From: Bloomer, David <David.Bloomer@lancashire.gov.uk>
Sent: 25 June 2018 12:34
To: Robert Major
Cc: LHS Customer Service; planning
Subject: app3/2018/0523 Fooden Old Hall Farm Bolton by Bowland

I am aware of a previous application for this site for the conversion of 2 barns to 5 dwellings 3/2018/0005. The principle of the development was considered acceptable by the highway authority however concern was raised regarding the visibility to the left for vehicles exiting Fooden Lane onto Gisburn Road. The application was subsequently withdrawn. The current application is for the conversion of 1 of the barns to a single dwelling and the issue of visibility at the access onto Gisburn Road has been addressed, therefore subject to the following conditions being attached to any permission that may be granted, I would raise no objection to the [proposal on highway grounds

2744.2^A

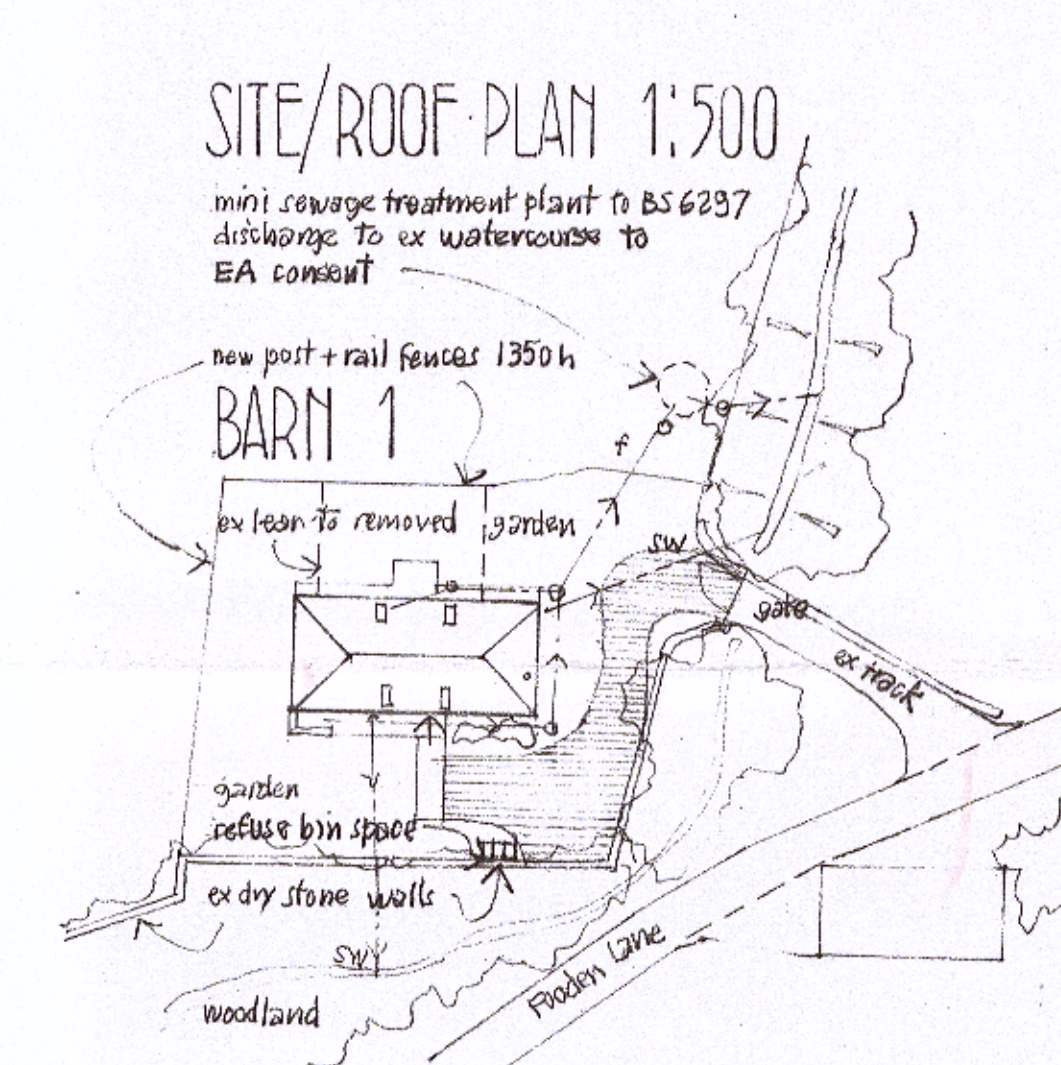
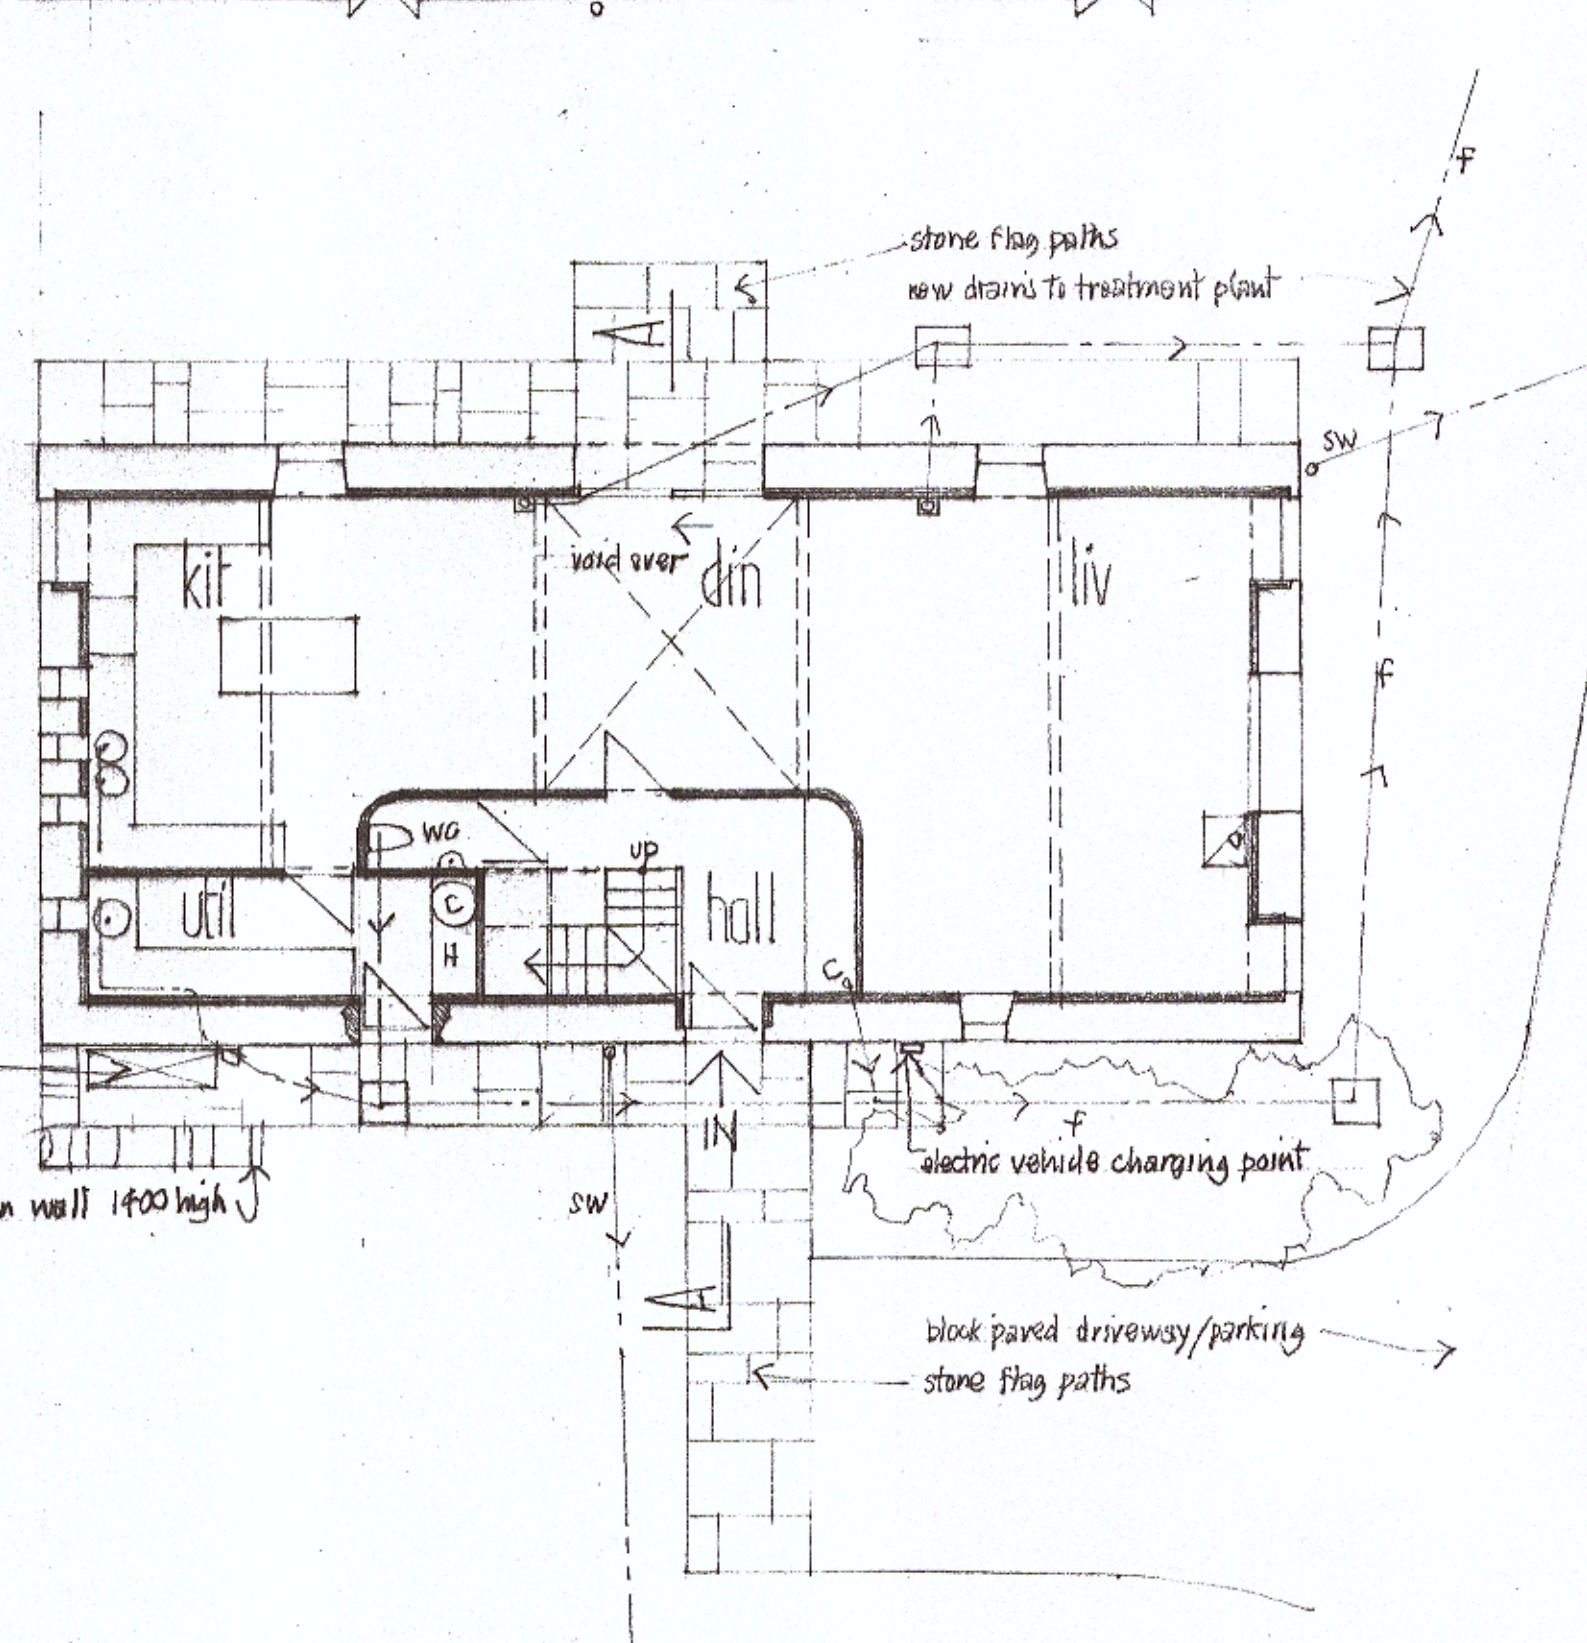
1. All new dwellings shall have facility of an electrical supply suitable for charging an electric motor vehicle. Reason: - in order to promote sustainable transport as a travel option and reduce thereby carbon emissions.

2. The layout of the development shall include provisions to enable vehicles to enter and leave the highway in forward gear and such provisions shall be laid out in accordance with the approved plan and the vehicular turning space shall be laid out and be available for use before the development is brought into use and maintained thereafter. Reason: Vehicles reversing to and from the highway are a hazard to other road users.

3. Before any of the new dwellings are occupied, that part of Fooden Lane extending from the highway boundary for a minimum distance of 5m into Fooden Lane shall be appropriately paved in tarmacadam, concrete, block pavements, or other approved materials. Reason: To prevent loose surface material from being carried on to the public highway thus causing a potential source of danger to other road users.

4. Notwithstanding the provisions of the Town and Country Planning (General Permitted Development) Order 1995 there shall not at any time in connection with the development hereby permitted be erected or planted or allowed to remain upon the land hereinafter defined any building, wall, fence, hedge, tree, shrub or other device over 1m above road level. The visibility splay to be the subject of this condition shall be that land in front of a line drawn from a point 2.4m measured along the centre line of Fooden Lane from the continuation of the nearer edge of the carriageway of Gisburn Road to points measured 209m in each direction along the nearer edge of the carriageway of Gisburn, from the centre line of the access, Fooden Lane and shall be constructed and maintained at footway/verge level in accordance with a scheme to be agreed by the Local Planning Authority in conjunction with the Highway Authority'). Reason: To ensure adequate visibility at the street junction or site access.
